V3_Final Plat Drawings.pdf Markup Summary

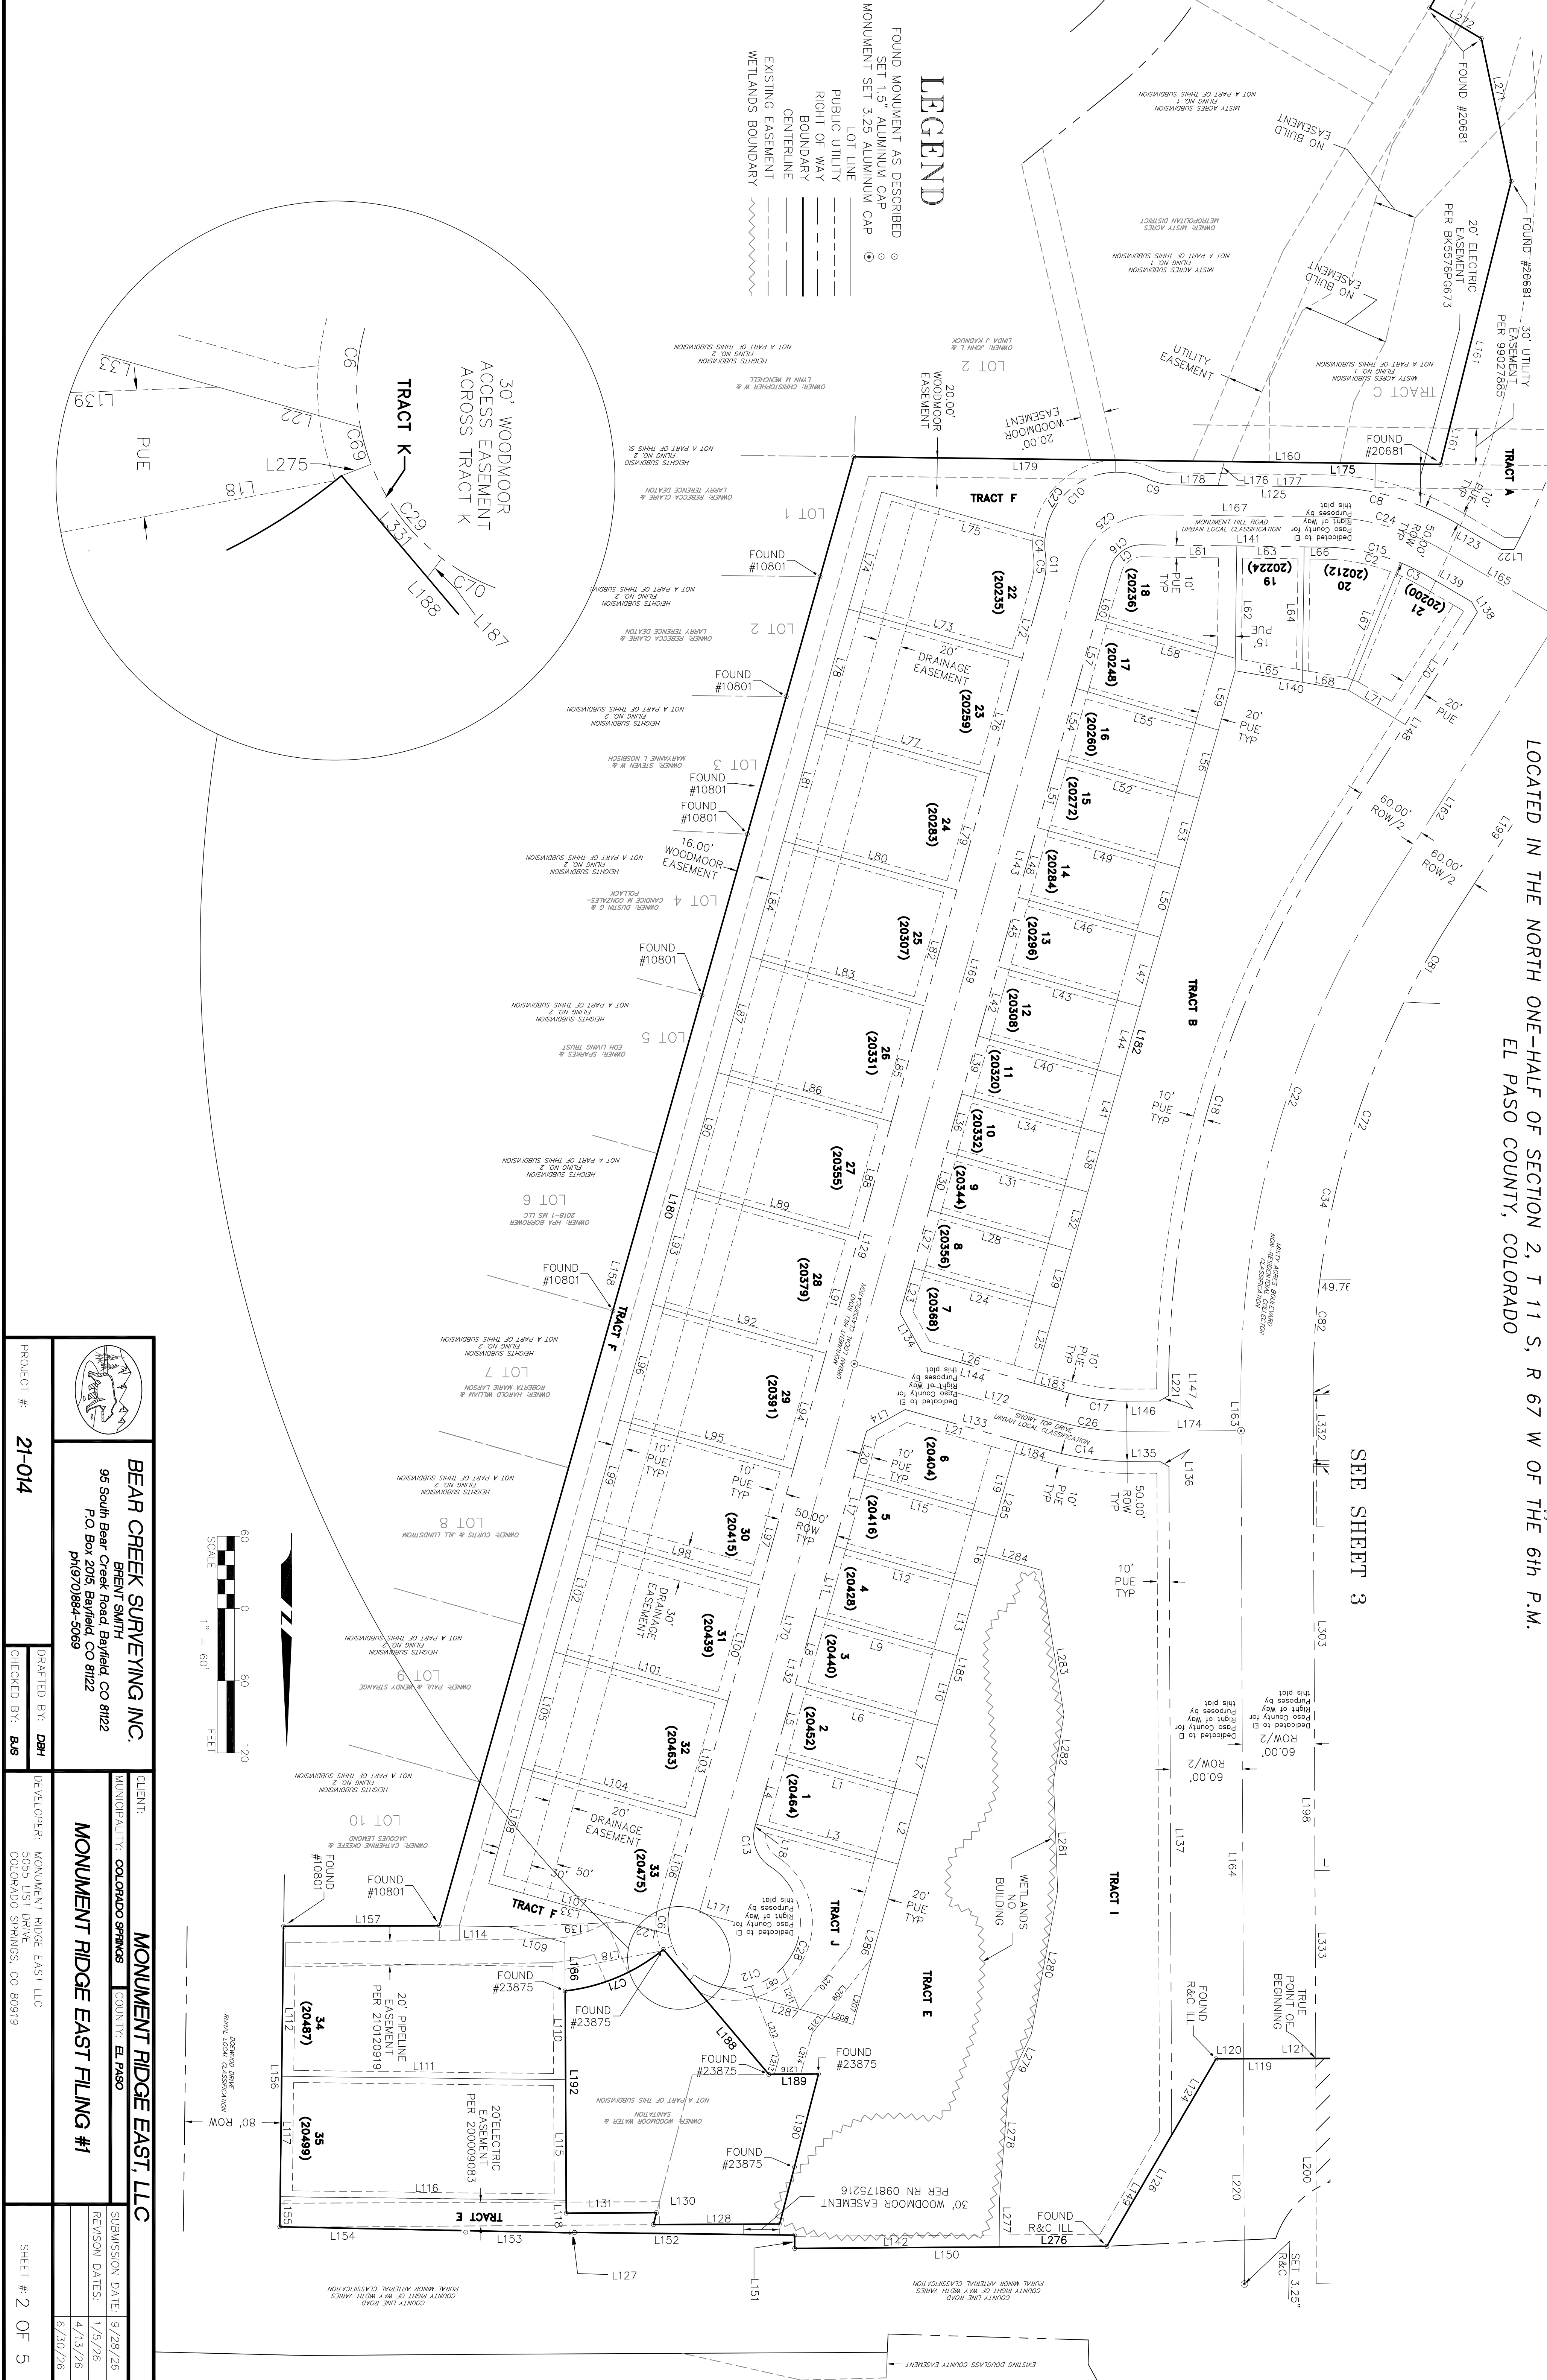
Is the highlighted area Tract E? or is it the dashed lines that extend into a separate subdivision?

If this is not Tract E, what is this easement?

Show access easement between lots 36 and 37 and how the 30' access easement comes off Tract O and into lot 36

Identify roadway classification for each Right of Way

Include a legend of the line work

added linetype legend to help clarify this is part of tract E

added linetype legend to help clarify this is part of tract E

dashed line indicates existing MVEA easement

access easement across tract o (now tract K) is in benefit of woodmoor to access the utility facilities

add note 19 for roadway classifications

added a legend of monuments and linetypes

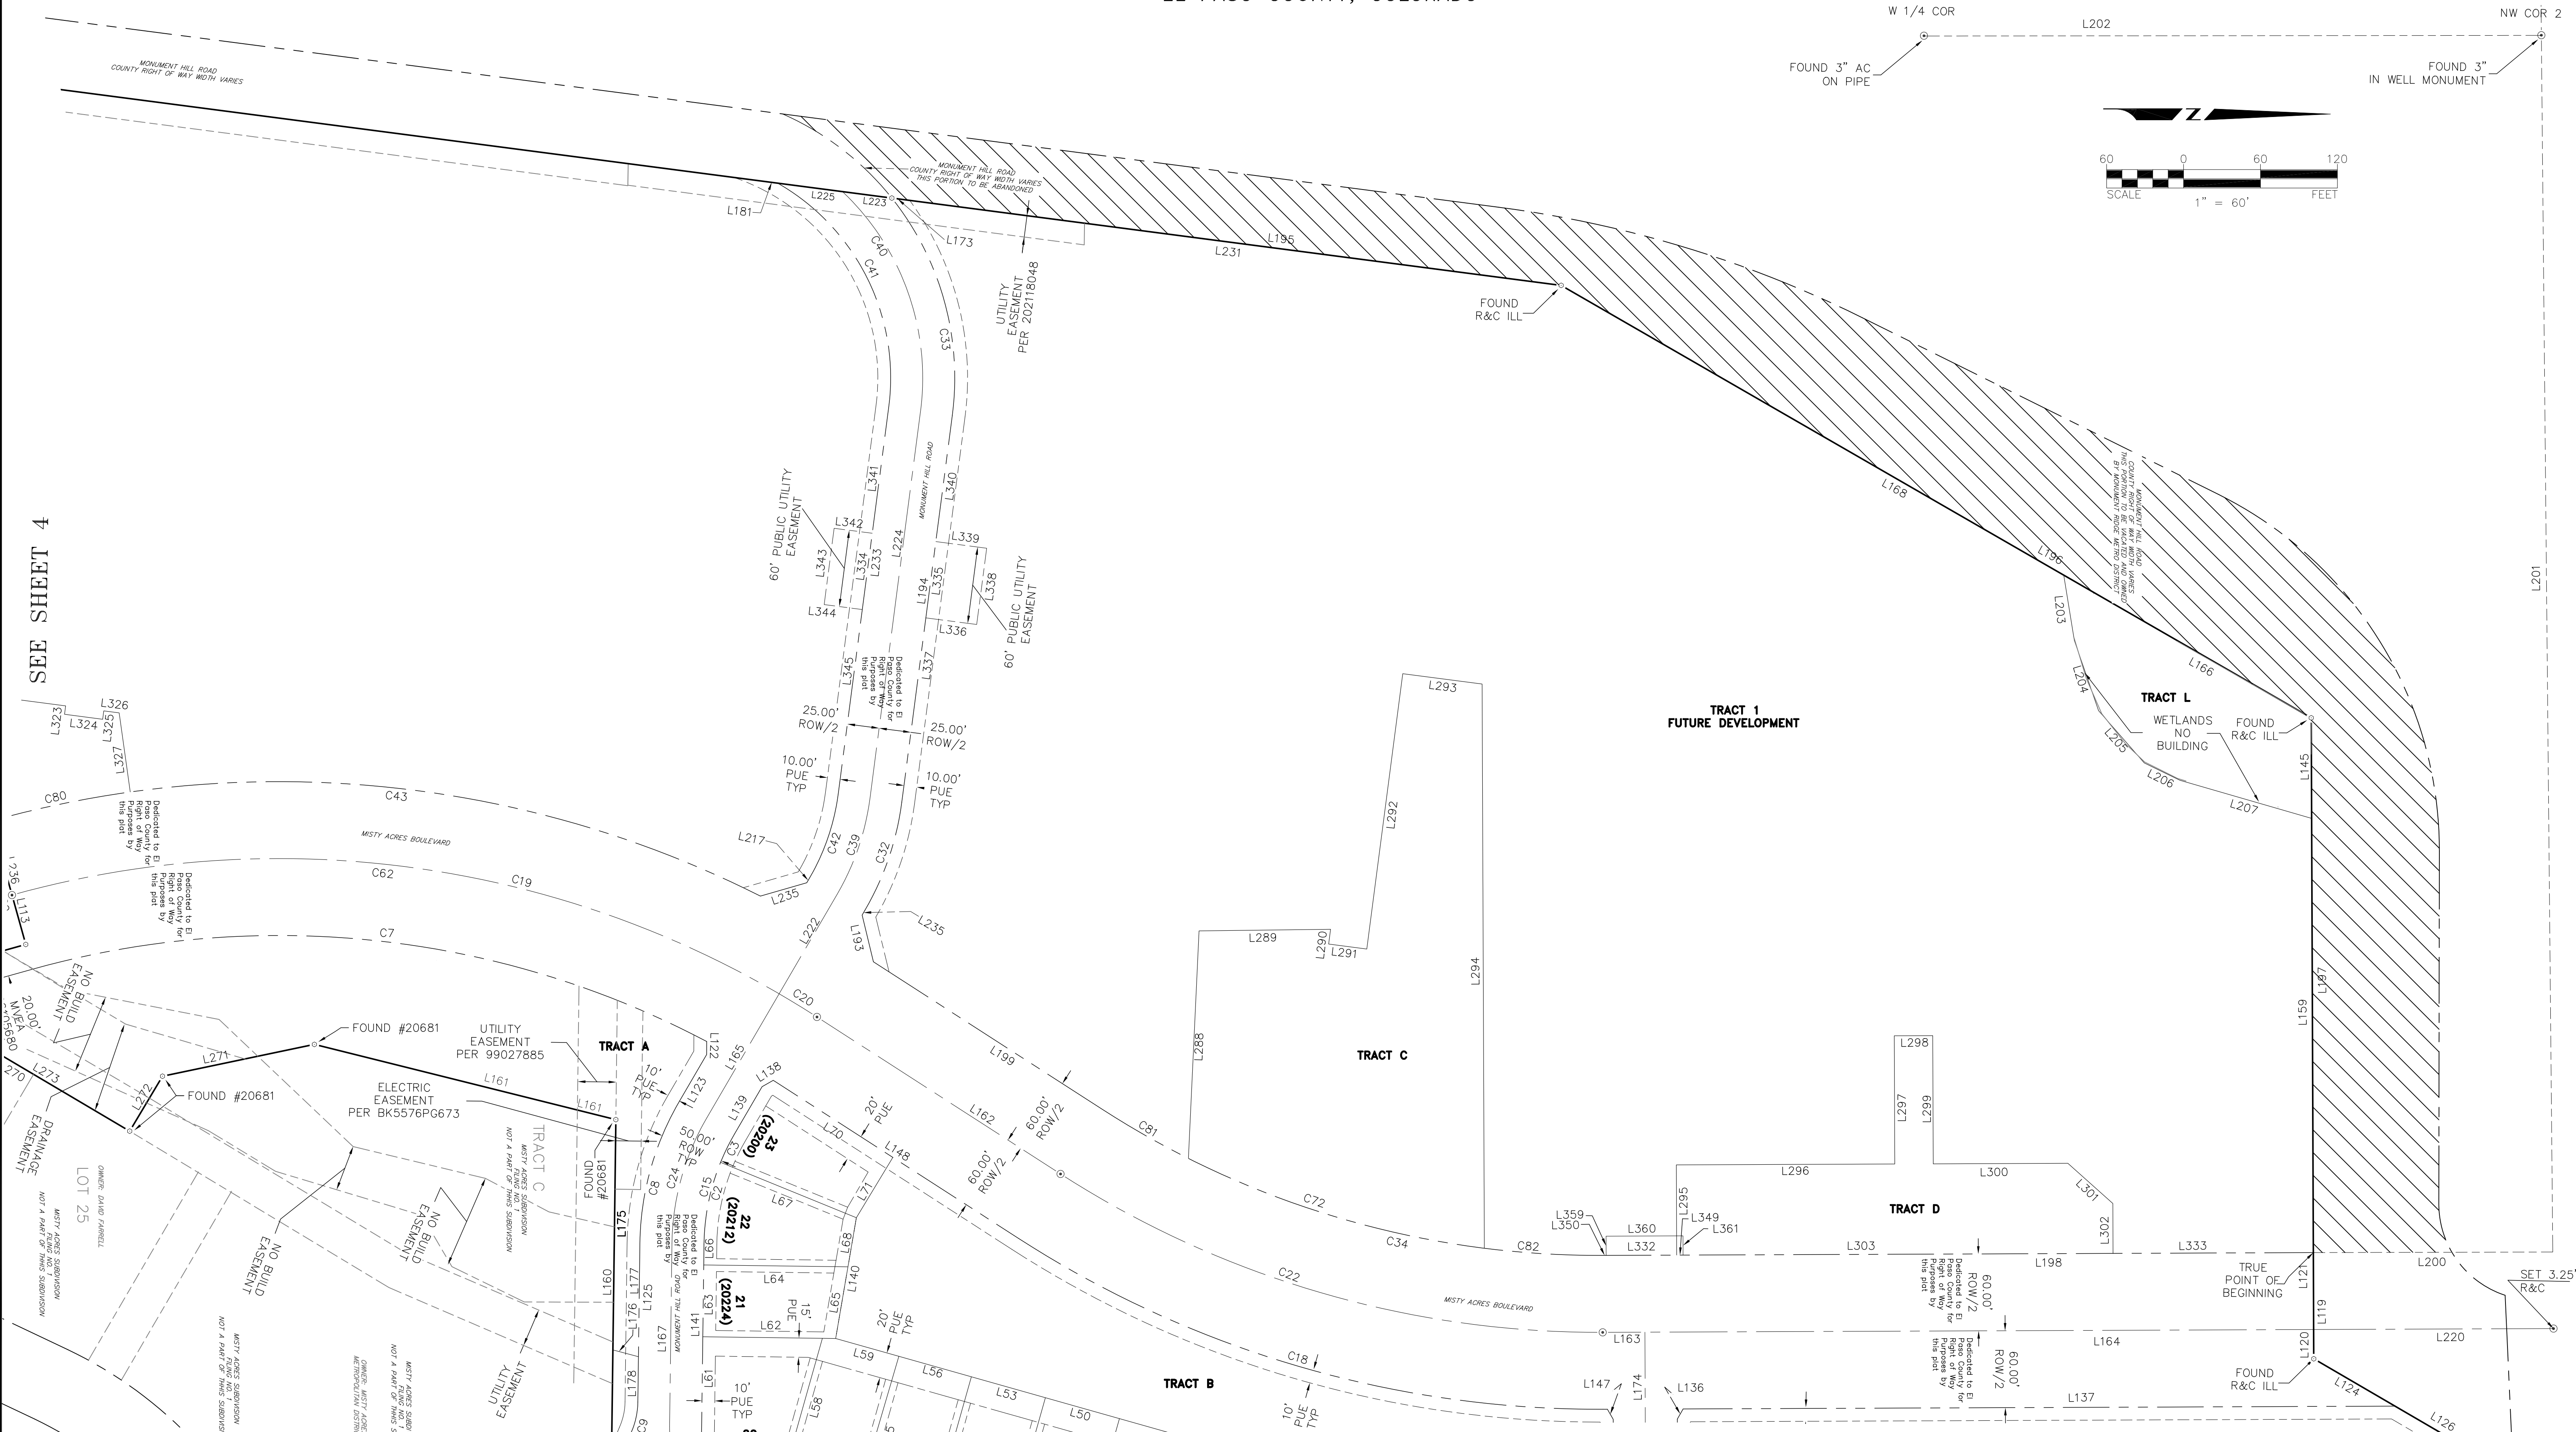
Unresolved Review 1 comment:
 Label Point of beginning from legal.

All roadway intersections of Collector classification and above shall be monumented at the centerline intersection at completion of construction. A metallic pipe or rod possessing a magnetic field and having a minimum outside diameter of 5/8" (#5 Rebar), a minimum length of 18", and a two-inch minimum diameter durable metallic cap marked with PLS No. (2.5" cap preferred) shall be installed in a load bearing survey monument box. The top of the box shall be set flush with the surface of the pavement. The monuments shall be located (with linear and angular dimensions) and described on the Final Plat.

Who is this ROW being given to (County/CDOT?)

ROW should be vacated, not abandoned

changed the label POB to Point of Beginning

added monument symbol to the legend and shown on Misty acres

right of way abandonment shall be owned and maintained by Monument Ridge metro district

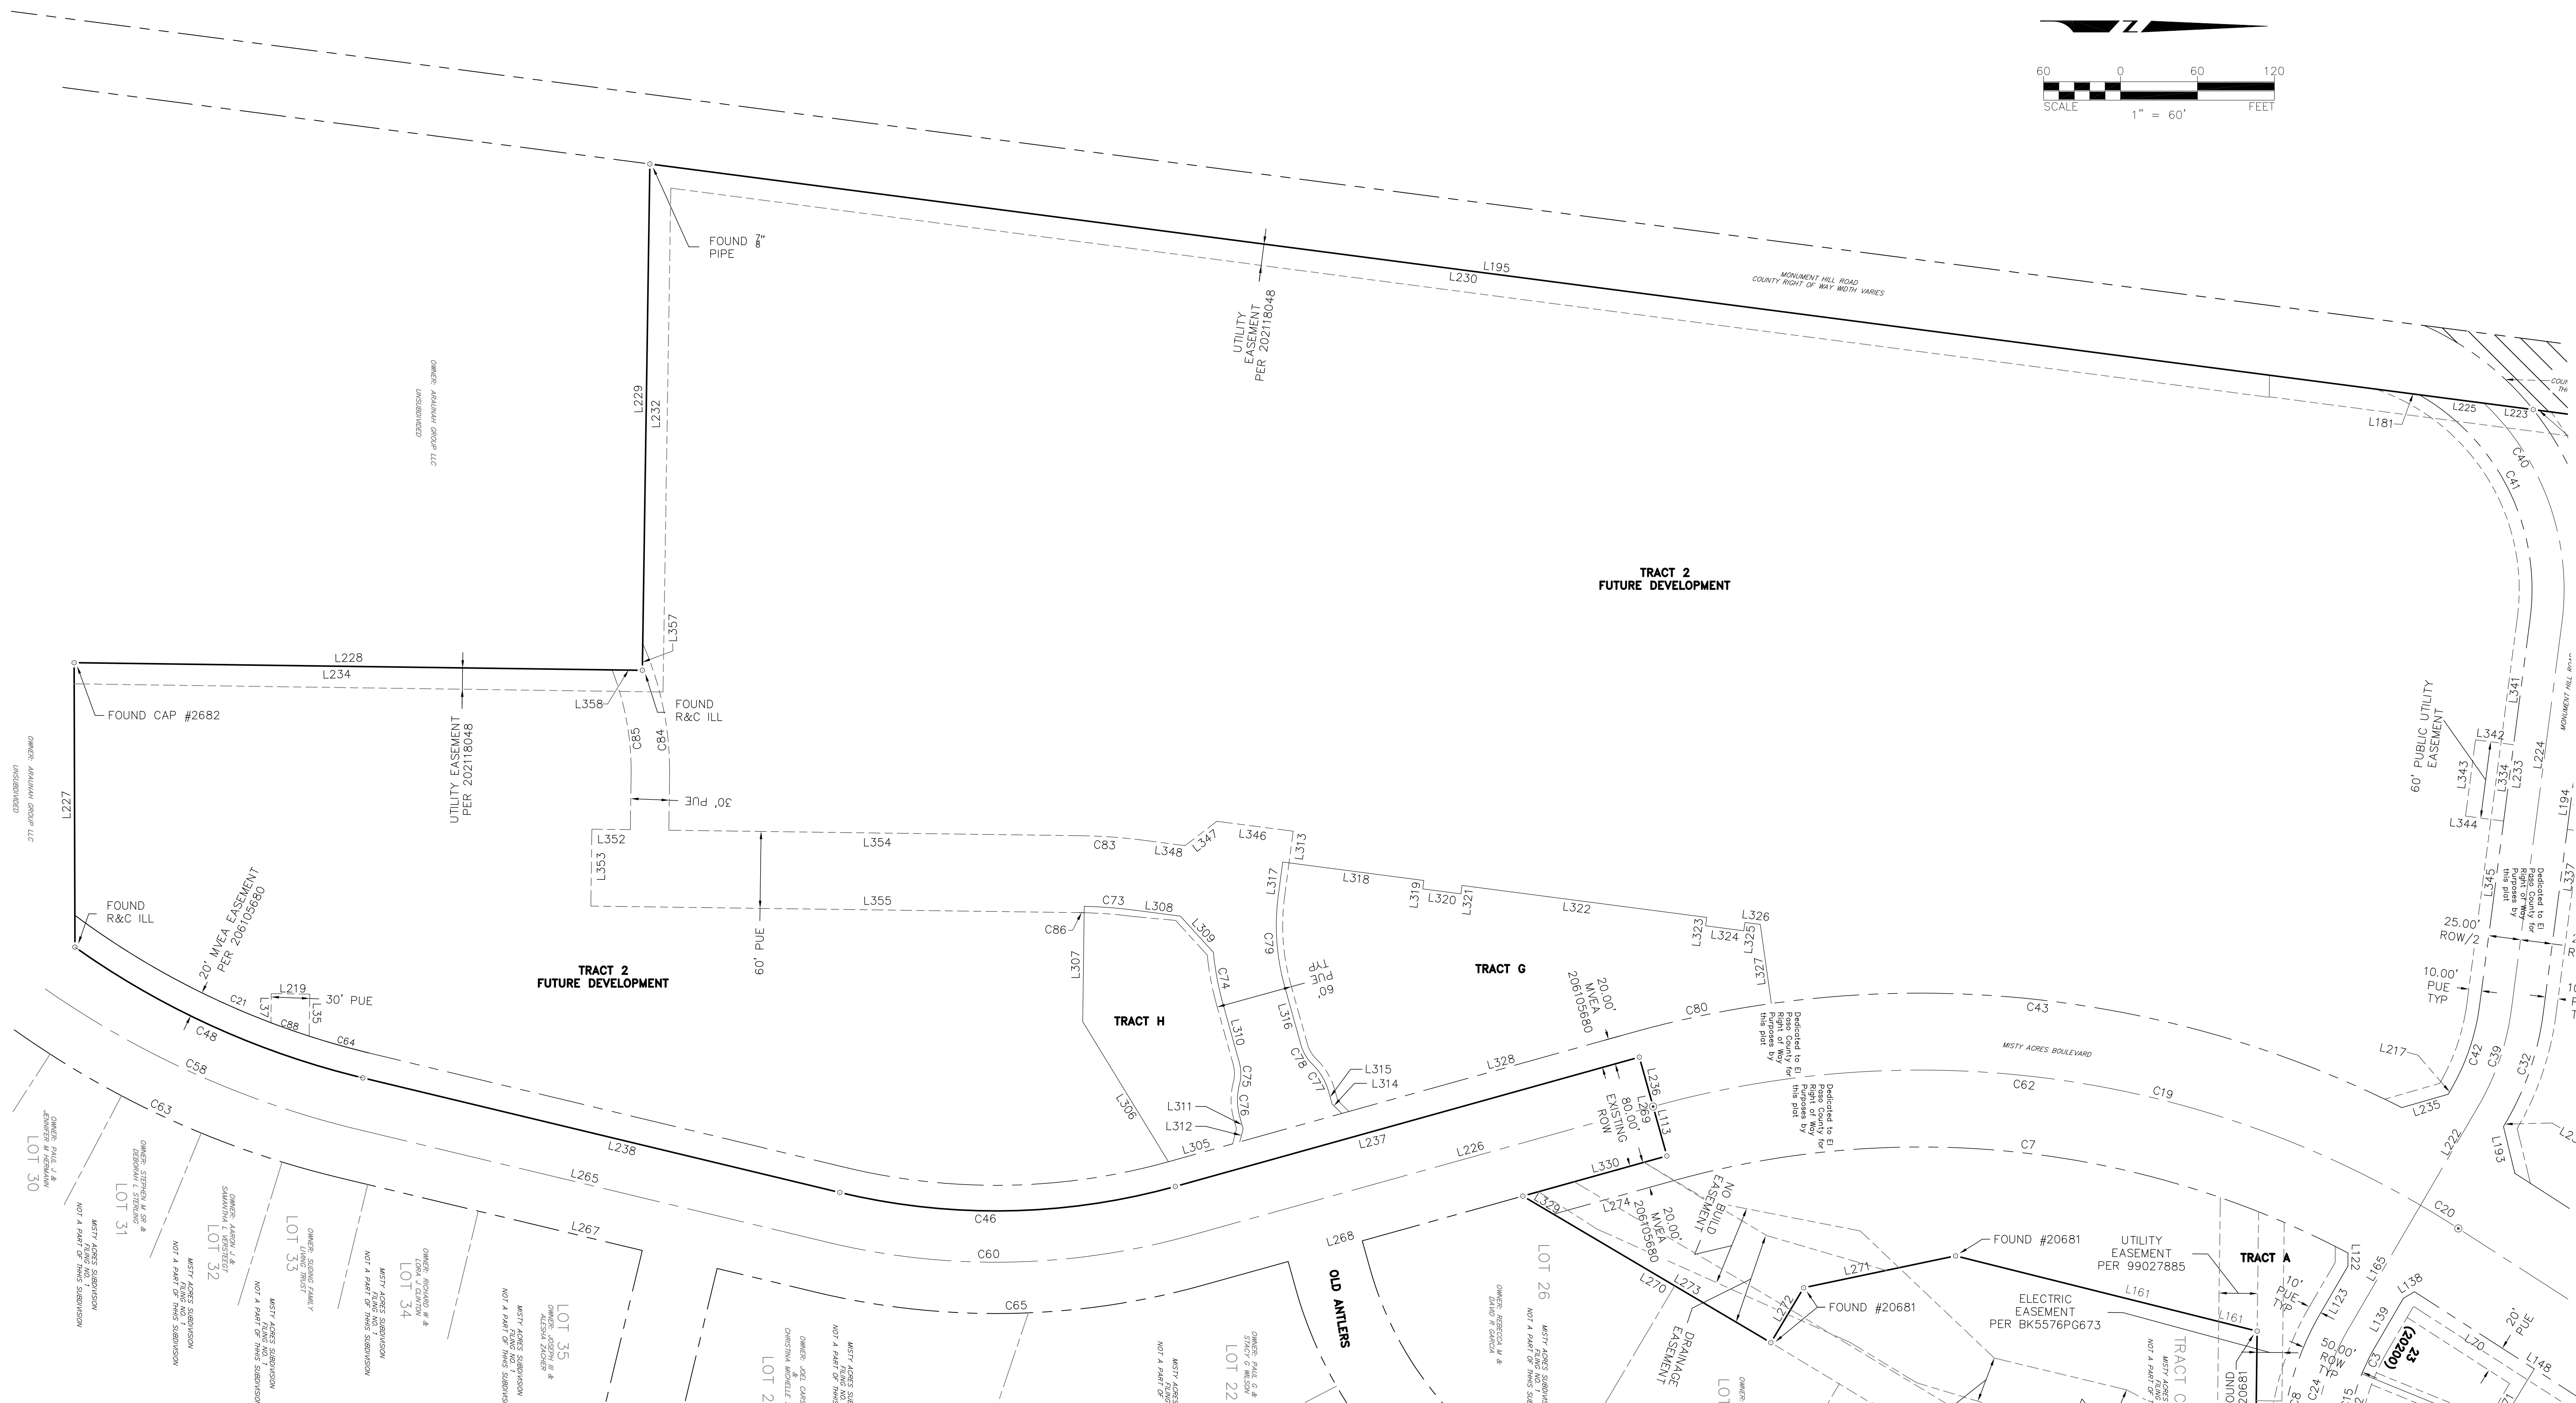
There is already a tract 2

Is this large open space a tract for future development?

Please label accordingly

tract 2 label has been removed

added tract 2 label
